2024/0827

1 Longside Way, Pogmoor, Barnsley, S75 2JL

Conversion of existing garage to bedroom and erection of a front linked garage

Drawing Title
PROPOSED ELEVATIONS

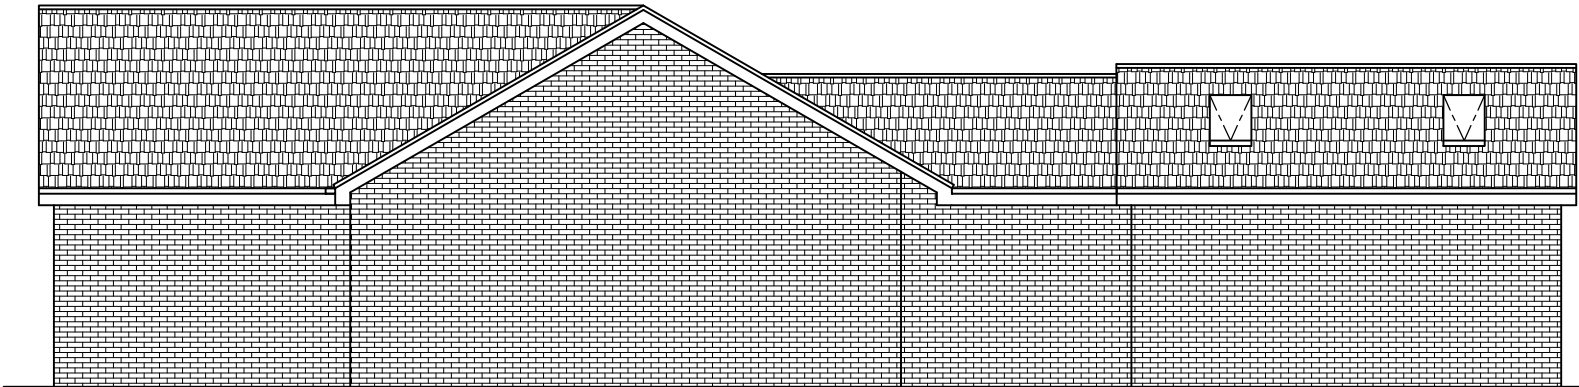
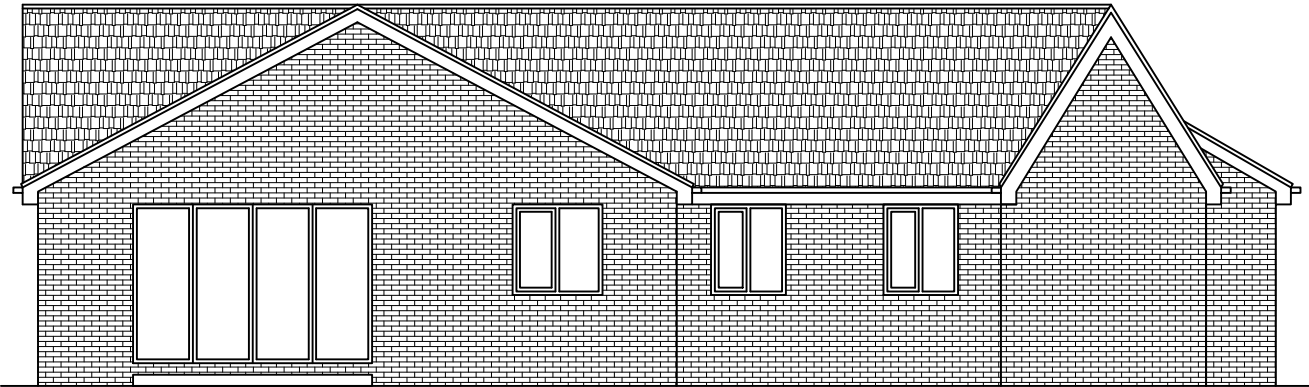
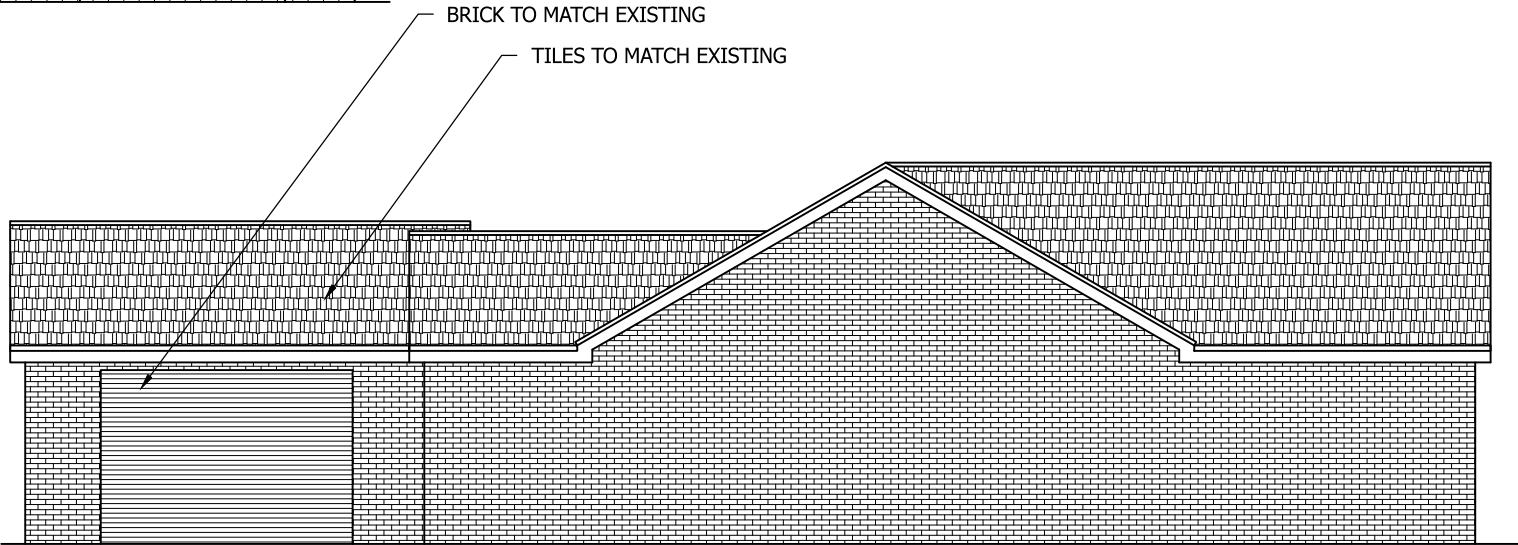
The proposed front extension is considered overly dominant on the street scene. The proposal would create a blank gable elevation in close proximity to the highway, detracting from the character of the street scene. The proposed blank elevation detracts from the character of the property by the loss of the existing garage door facing the highway with the replacement of an overly prominent blank gable elevation. The proposal is forward of the general principal elevation line of the surrounding area which is not consistent with the street character and is not in compliance with the adopted supplementary planning document House Extensions and Other Domestic Alterations and the harmonious pattern and continuity of the street scene to its detriment.

Although single storey and gable roofed, the proposal is considered overly dominant and detracts from the character of both the host dwelling in that it is of a larger scale than the existing gable element, and windowless which cause the dwelling to appear asymmetrical and unbalanced. This would make the dwelling appear incongruous and out of character within the street scene. This would be exacerbated by the significant frontways extension which would be prominent within the streetscene in an area where there are no similar large front extensions. The use of matching materials is acknowledged.

The proposal is therefore considered to significantly alter or detract from the character of the street scene and is considered to not comply with *Local Plan Policy D1: High Quality Design and Placemaking* and would therefore be unacceptable regarding visual amenity.
